INSIGHT ENGINEERING CO.

October 2, 2024
Amy Hess
501 Delta Ave
Marysville, WA 98270
360-363-8000

Re: **MSR Tuscany Woods**
IECO No. 22-1215

The applicant for the above referenced project would like to request a minor revision to the site plan.

MSR TUSCANY WOODS
DWG FILENAME: 221215-PRELIM.DWG DESIGNED BY: JTK DATE: 05-10-2023 SCALE: 1"=40' JOB NO.: 22-1215 SHEET: S1

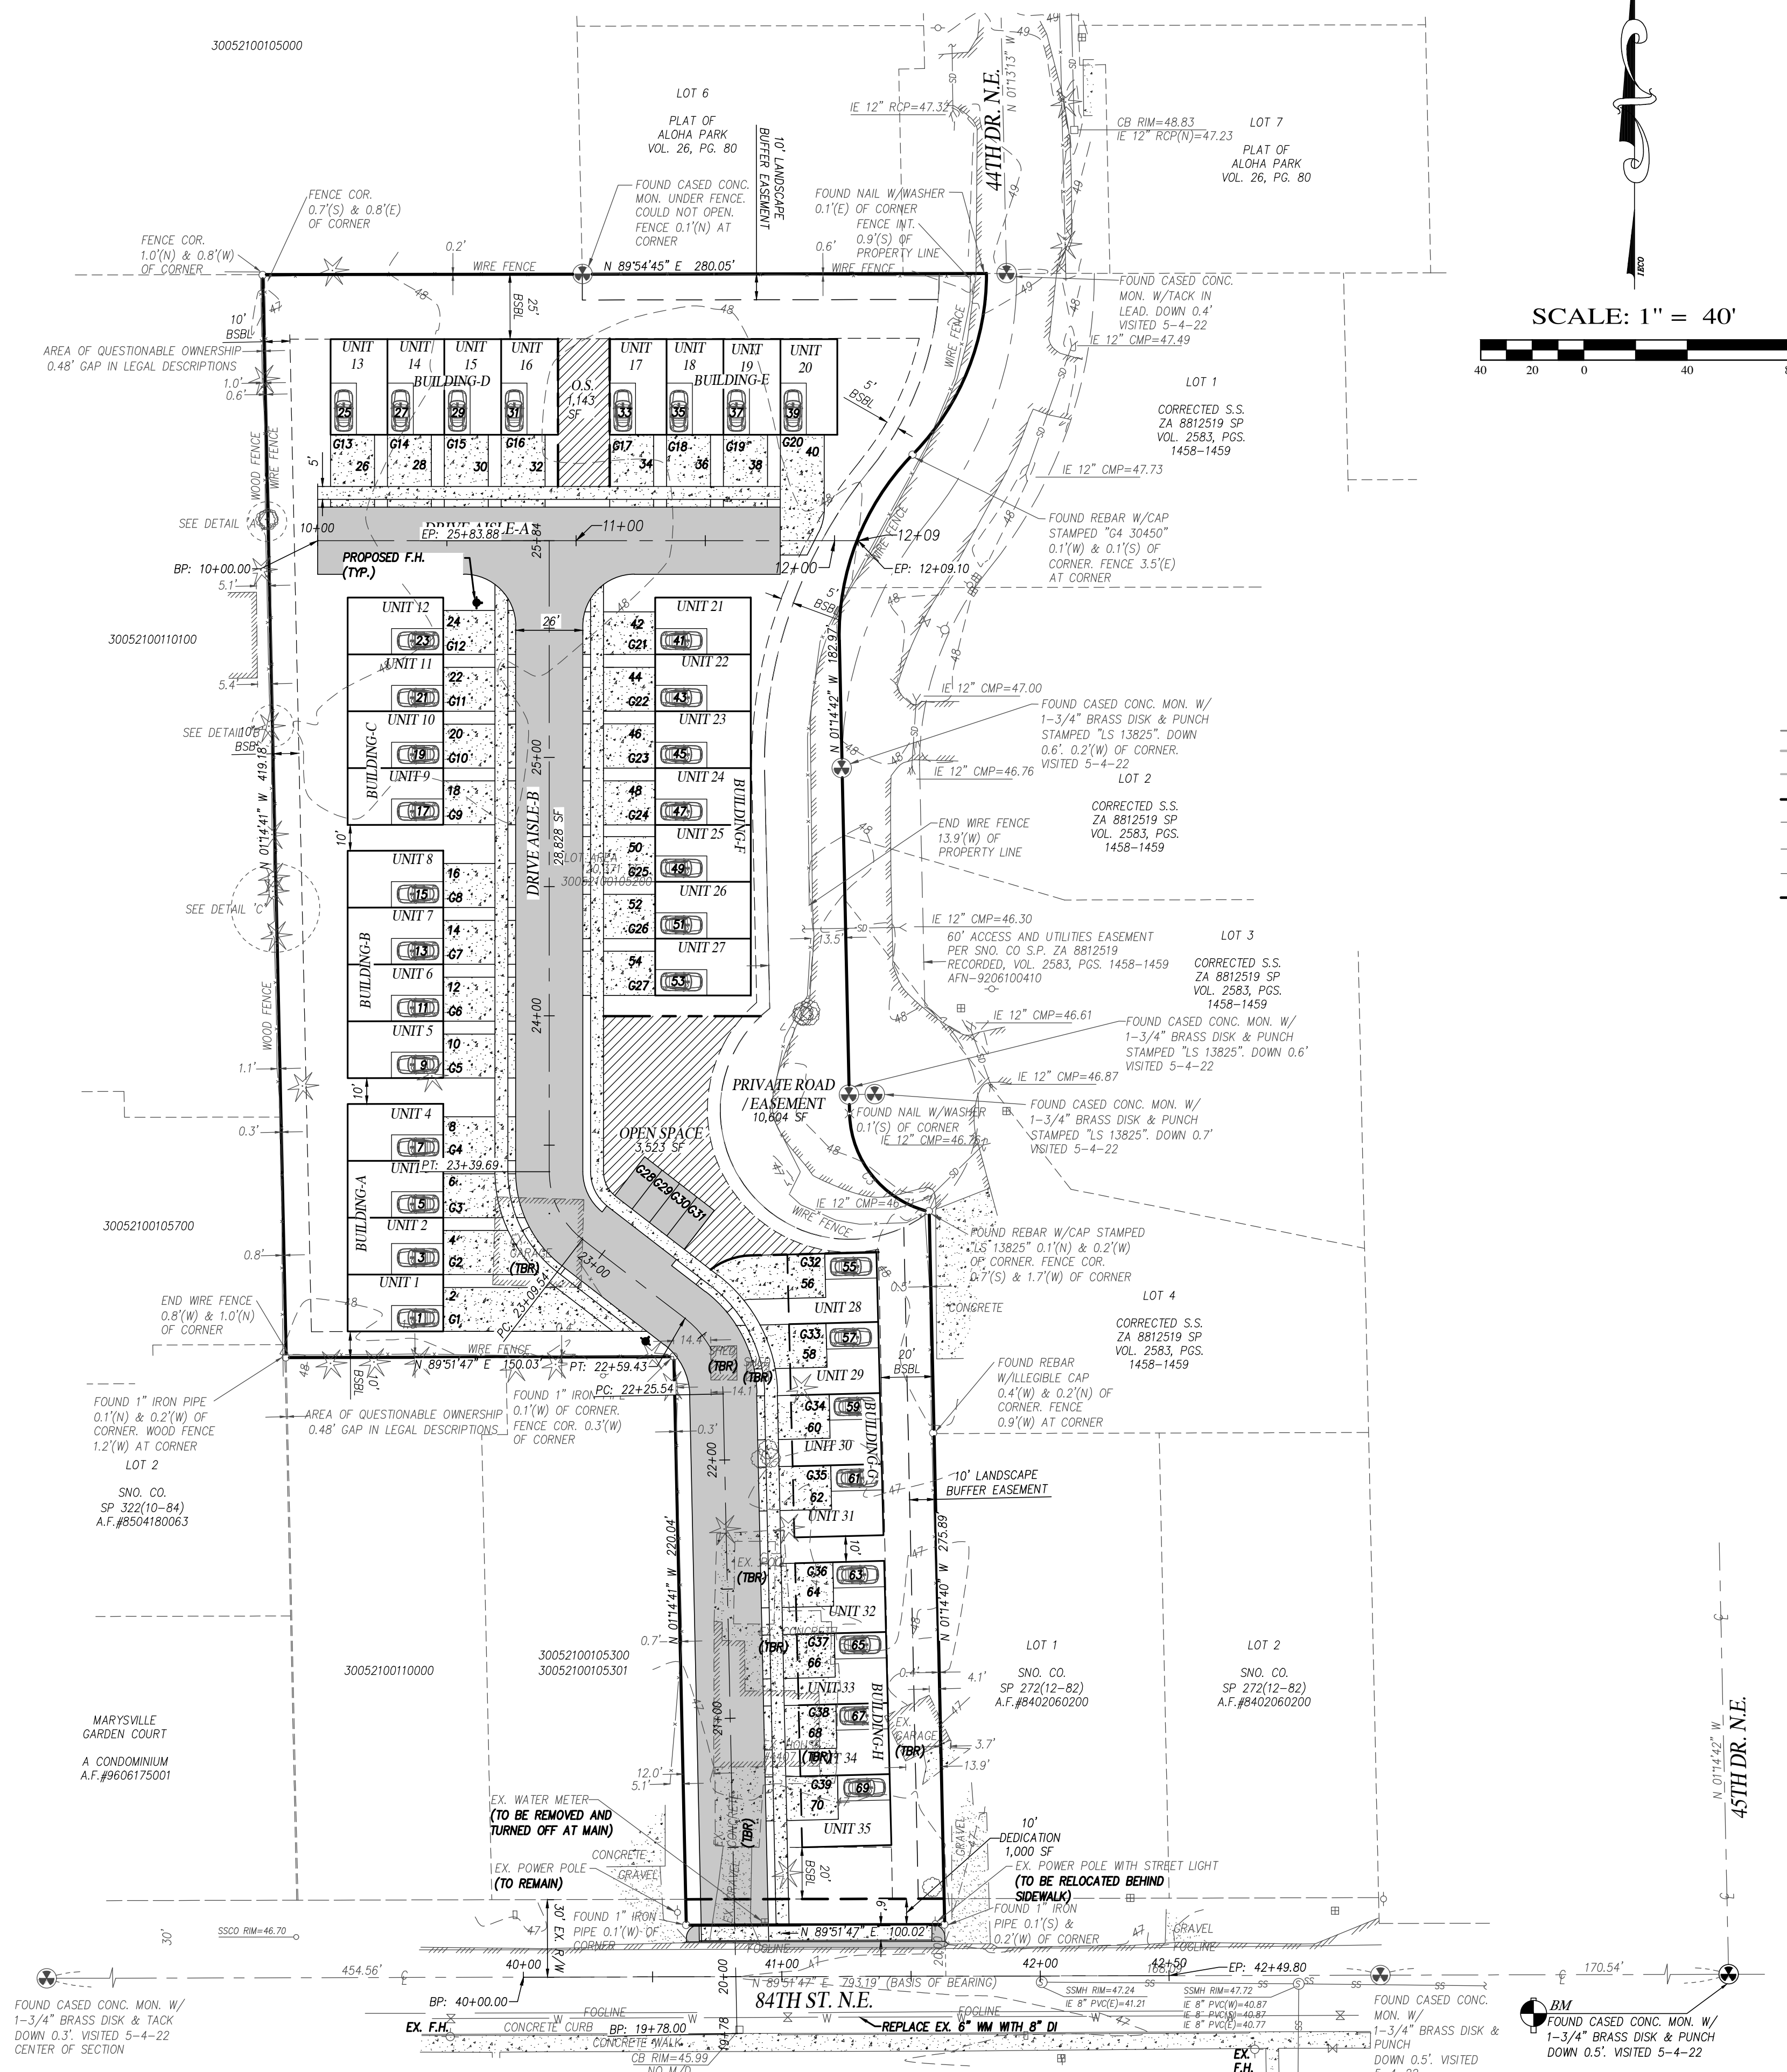
The minor revision includes a slight shift of the buildings onsite, slightly increased building size for units 1-27 (3' longer, from 37' to 40' in length), and a slight shift of the road to give better backyards for units xx-27.

The access point is not changing, but the drive aisle location in the north portion of the site is shifting to the east by 10' and the northern T will shift south by 3'.

The open space increased on the whole, from 3523 to 4037 sf thanks to the shift in the road.

The exact location of the buildings shifted, and the size of buildings A-F increased slightly. These do not significantly change the project's character.

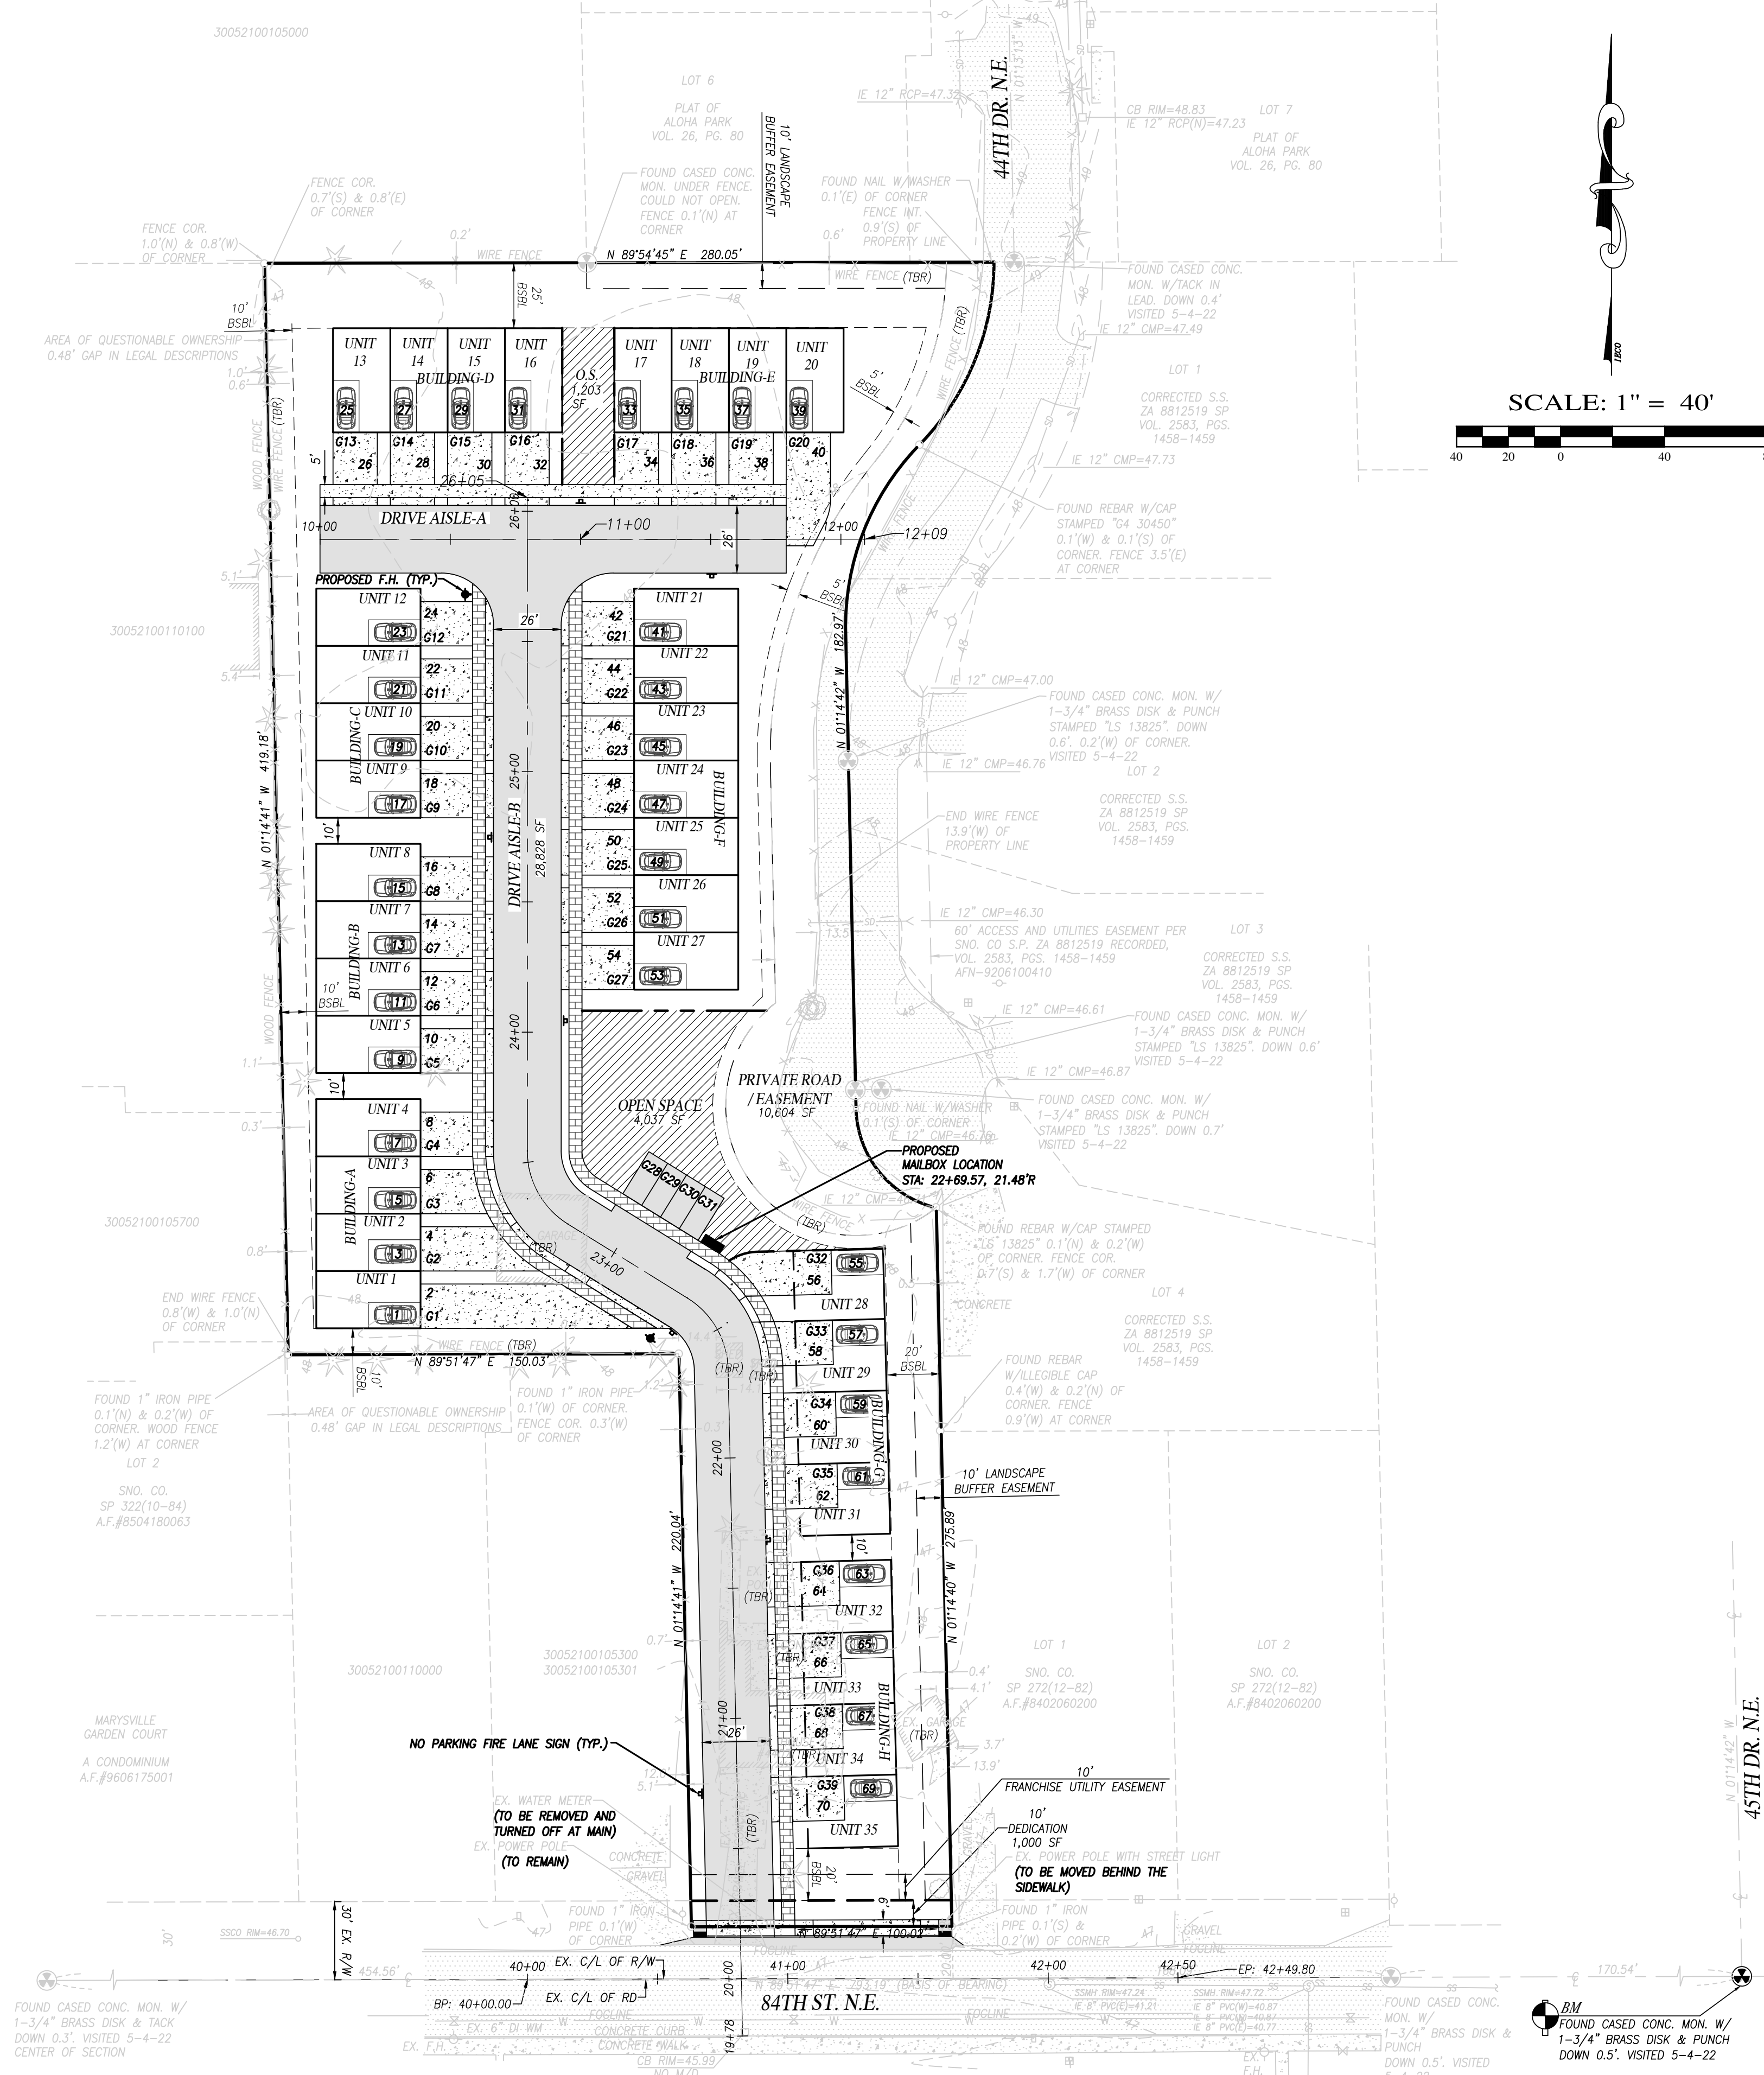
The number of units has not changed. The location of the buildings have shifted and some of the buildings have gotten bigger, increasing onsite lot coverage from 32,648 sf to 34,430 sf. However, the latter number remains within the zone limit of 50% or 60,186 sf. In addition, the common open space has gotten bigger, and the individual open space areas have also remained acceptable, with at least 100 sf at each lot, and at 4,037 sf, there is ample space to put the substitute space at each lot.
